<b>Consultation Response from KC, Highways Development Management</b>
<b>2023/91384 Land Adj, 28, Grosvenor Road, Dalton, Huddersfield, HD5 9HZ</b>
<b>Prior notification for 15m 5G telecoms installation: H3G street pole and additional equipment cabinets</b>
<b>Date Responded: 01/06/2023. Responding Officer: D. Stainsby Responding Ref: K12-14/19</b>

This application is for a proposed 5G telecoms installation: H3G 15m street pole and additional equipment cabinets.

Title: **215 PROPOSED SITE PLAN**

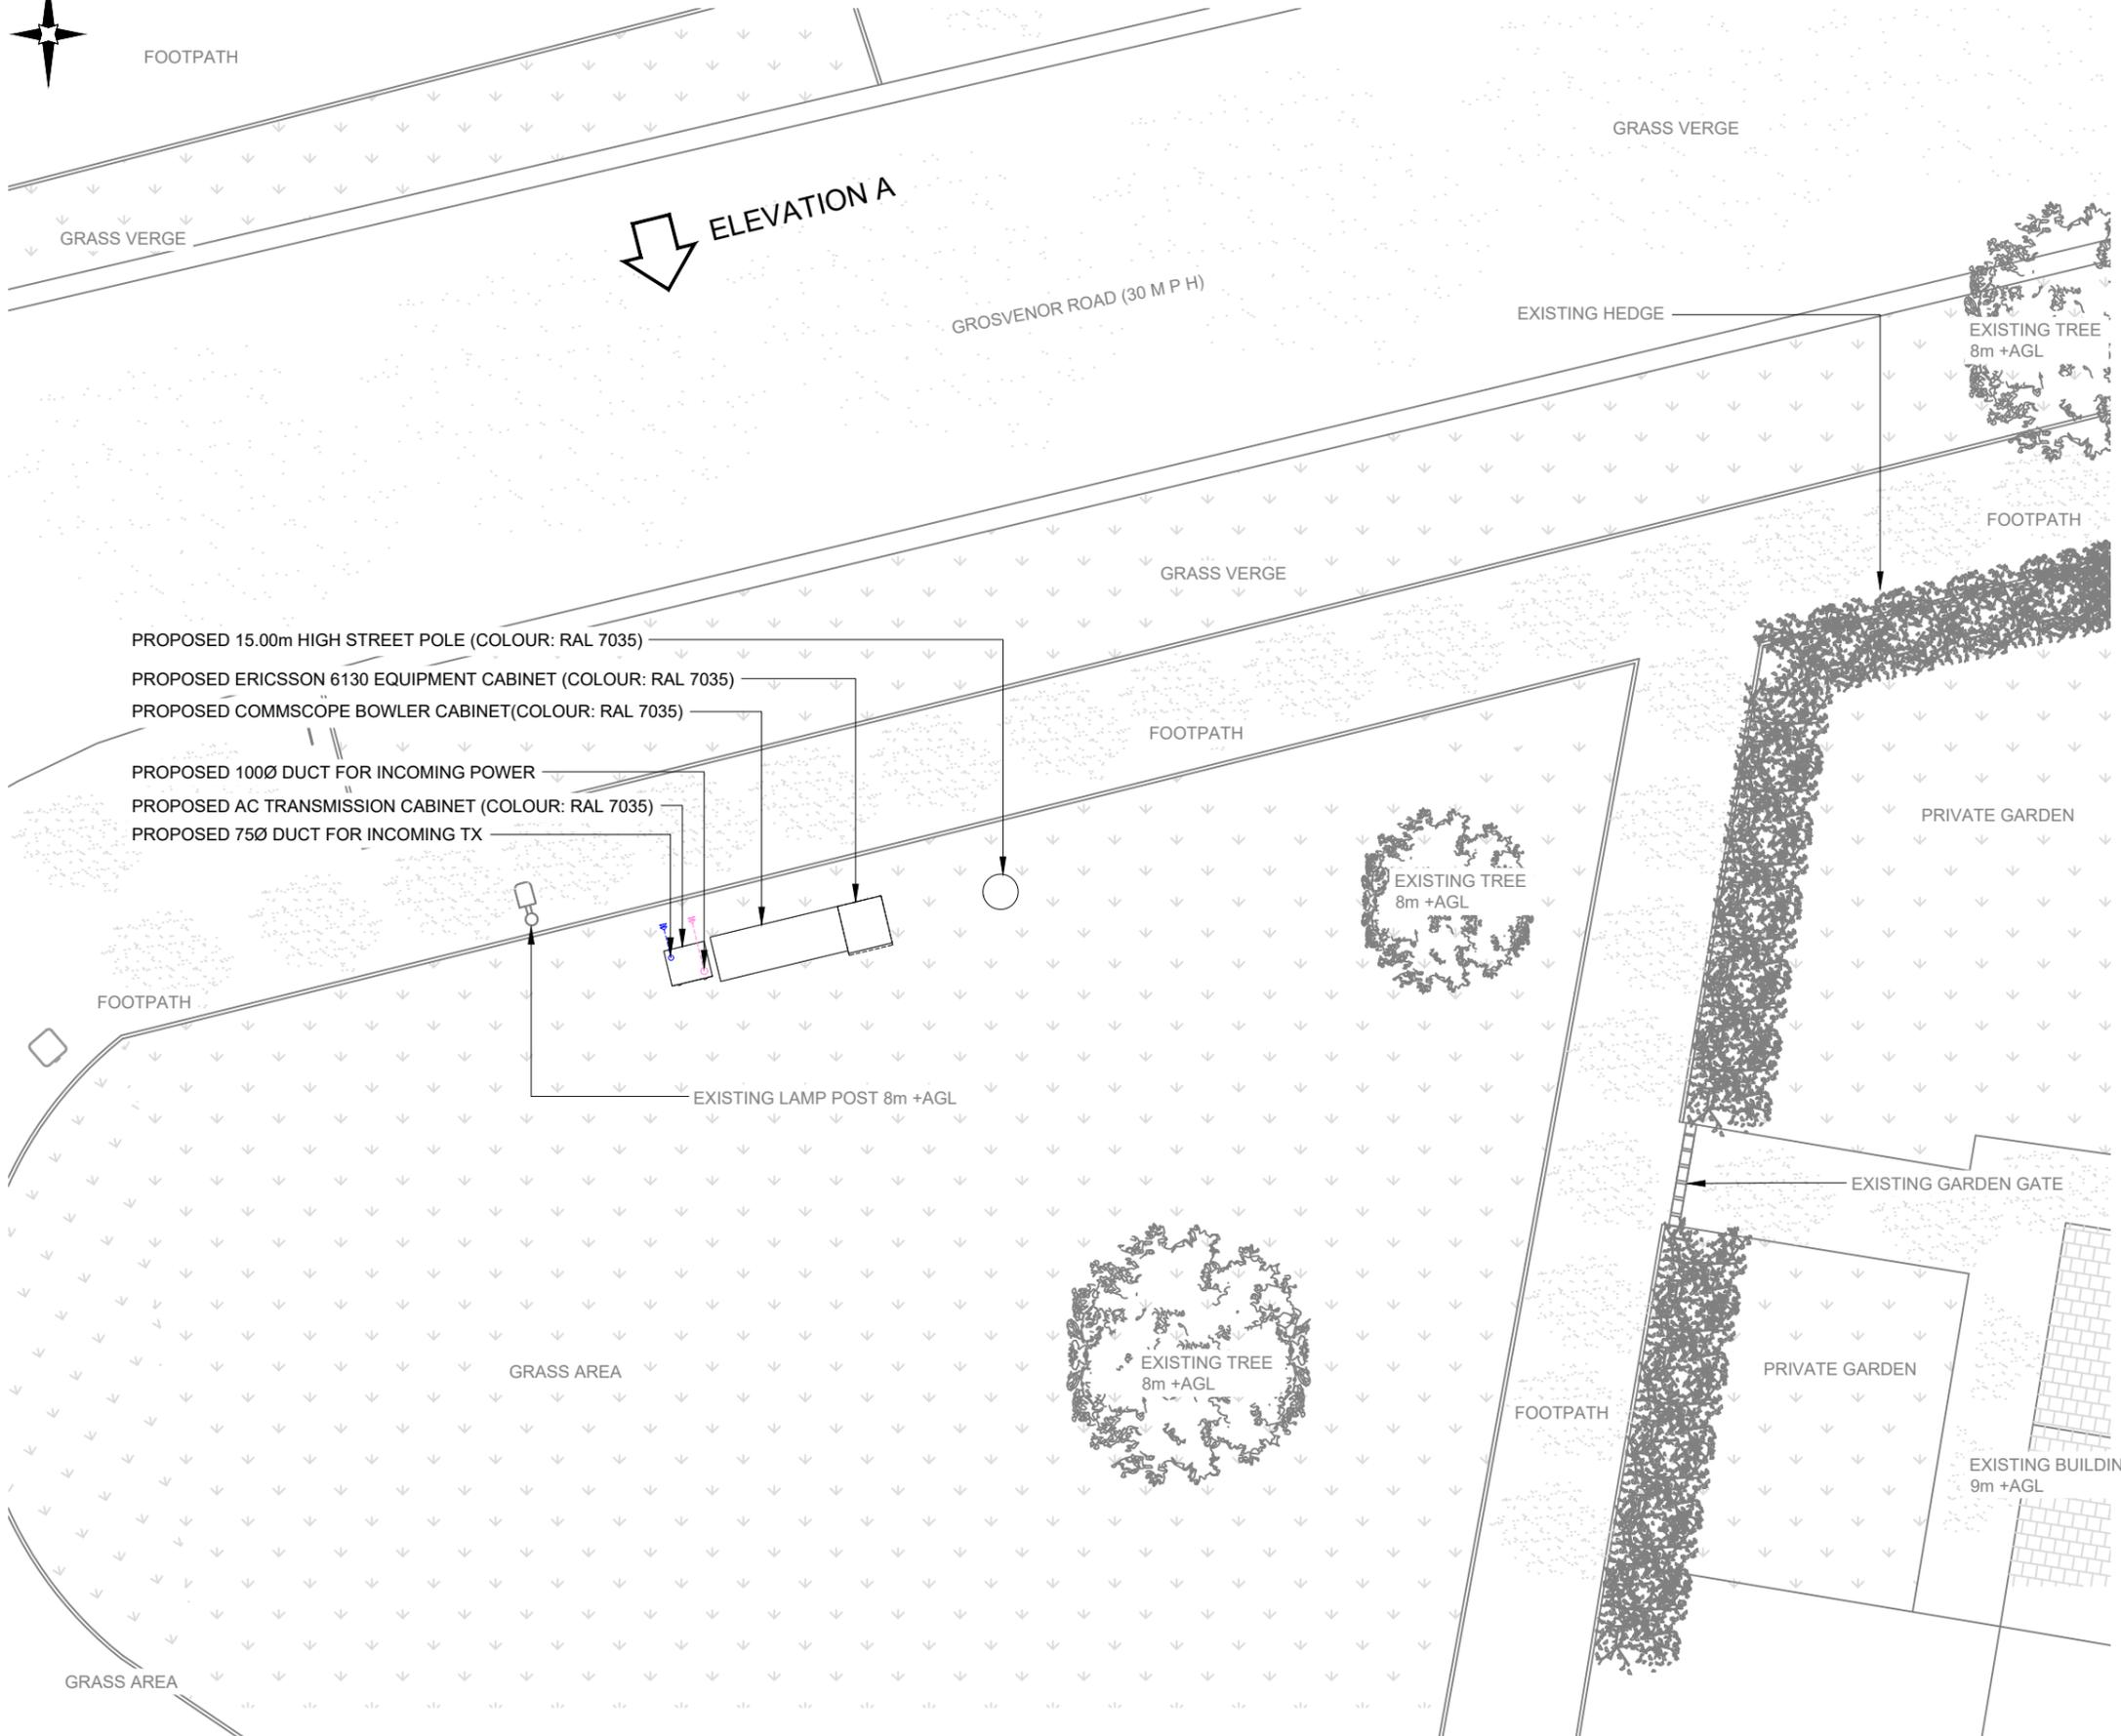
The site is located on a wide verge at the back of the footway and is set back far enough so as not to impact visibility splays at the junction of Grosvenor Road and Kingston Avenue and does not obstruct the footway.

However, a condition requesting a construction management plan for the installation of the equipment and a maintenance plan for the ongoing maintenance of the equipment will be required.

The siting of a crane within the highway adjacent to this junction will cause an obstruction and require traffic management.
